Application No: WA/30/20/PL
Site Address: Spindlewood Yapton Lane Walberton BN18 0AS
Description of works: Demolition of existing dwelling & erection of 8 No. dwellings with associated landscaping, parking & works. This application is a Departure from the Development Plan.

Thank you for your internet representation made on 5th June 2020 which has been recorded as an objection with the comments as follows:

Drawing.
Proposed Site Plan

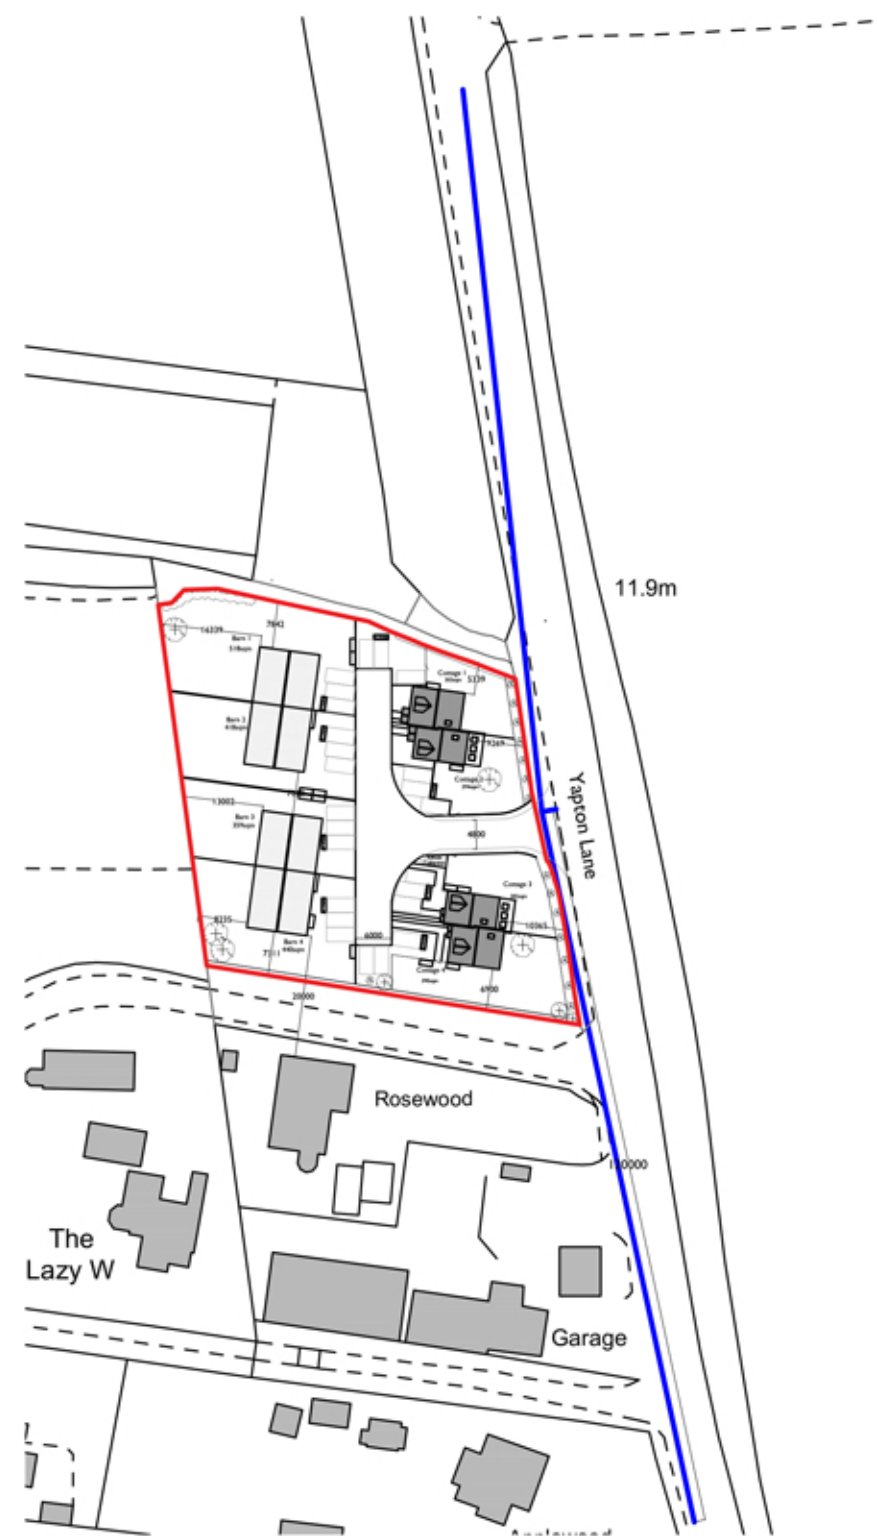
The Site Plan does not show the existing conifer tree line along the Western boundary, which adjoins my land. There is an existing chain link fence along the same line, on my side of the conifers which suggests the ownership of the trees are that of the Developers. They provide substantial visual and sound privacy benefits to my paddock, as well as an excellent wildlife habitat, which in my view should be preserved. In view of this, whilst I understand the Developers and Owners of the the proposed properties may wish to remove or reduce the size of the boundary, I would like specific details of a plan on the future treatment of it, to include environmental impact, replacement fencing or other boundary. I understand the ratio of replacement trees is 2:1. Where are they likely to be placed? If a fence is to be constructed, I must insist it to be a minimum of 2.4m in height and line of trees planted on the west side (on my land) to reduce the severity of the impact the removal of the conifers would make.

I would like specific details of the visibility splays for the exit onto Yapton Lane. Unfortunately, I did not make representation in time for amendments to the splays to the recent development of the former Progress Garage site to the south of this development and to the north of my industrial park access. As a consequence (despite WSCC Highways not taking responsibility for missing this), I now have considerable reduced visibility to the north, when exiting my access from Tokar Industrial Estate. This could have been easily resolved by setting back the new wall to the north, giving my Tenants and visitors the required 2.4m x 120m (Although I contended the use of the access is mainly for lorries and should have been 4.5m x 120m). You will

understand therefore, my concerns about the visibility requirements for the access to this proposed development. According to the Site Plan there is clearly a pinch point to the east roadside boundary to Cottage 3. I would like details of this splay to be clear on on future detailed plans and on any approved consent, in order the new boundary wall/fence will not preclude good visibility, for all types of vehicles exiting my two accesses to the north and south, onto Yapton Road.
